WEST SUSSEX COUNTY COUNCIL CONSULTATION

TO:	Arun District Council FAO: A Wood
FROM:	WSCC - Highways Authority
DATE:	10 March 2021
LOCATION:	18 Old Point Bognor Regis PO22 7RY
SUBJECT:	M/22/21/DOC Approval of details reserved by condition imposed under ref M/83/20/PL relating to Condition Nos 3 - materials & finishes and 4 - charging for electric vehicles.
DATE OF SITE VISIT:	n/a
RECOMMENDATION:	Advice
S106 CONTRIBUTION TOTAL:	n/a

This application seeks discharge of conditions 3 and 4. The LHA will provide comments in regards to Condition 4 - charging for electric vehicles.

CHARGING POINT
POSITION PLAN
1:50 @ A3

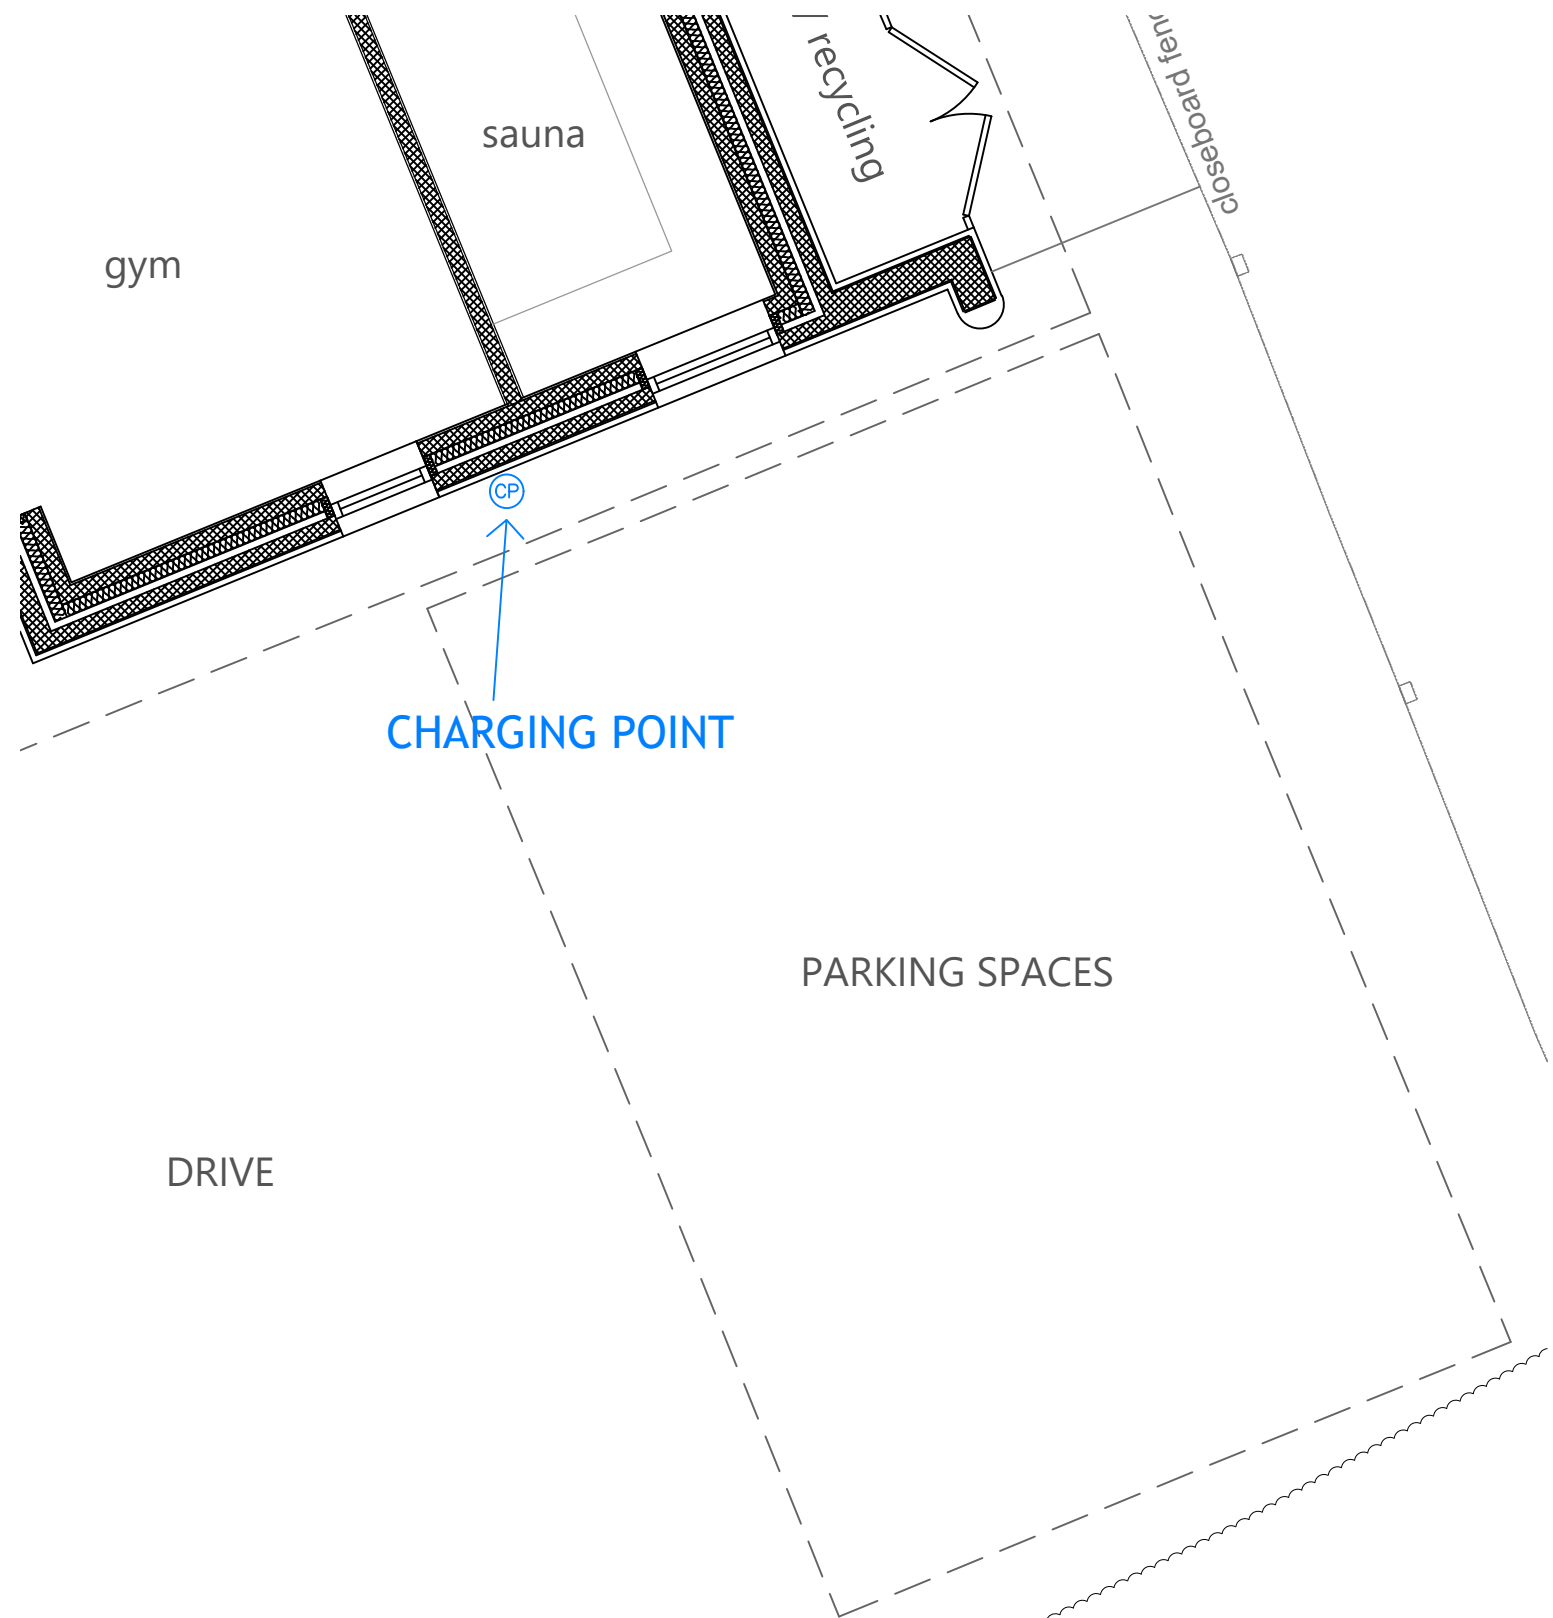
The applicant has demonstrated that a single electric vehicle charge point will be provided to serve the three approved parking spaces for the dwelling. This is acceptable to the LHA as it meets the minimum required provision of EV charging facilities in accordance with the WSCC parking guidance. However, the Arun Parking Standards (adopted January 2020) set out a requirement for 100% of parking spaces to be provided with active EV charging facilities. Whilst the LHA would not raise any concerns to the proposed EV provision and is satisfied that this condition could be discharged, the LPA may wish to consider whether the proposed provision is acceptable given the Arun Parking Standards.

As above, the LHA is satisfied that Condition 4 could be discharged, however the LPA may wish to consider the provision in line with the Arun Parking Standards.
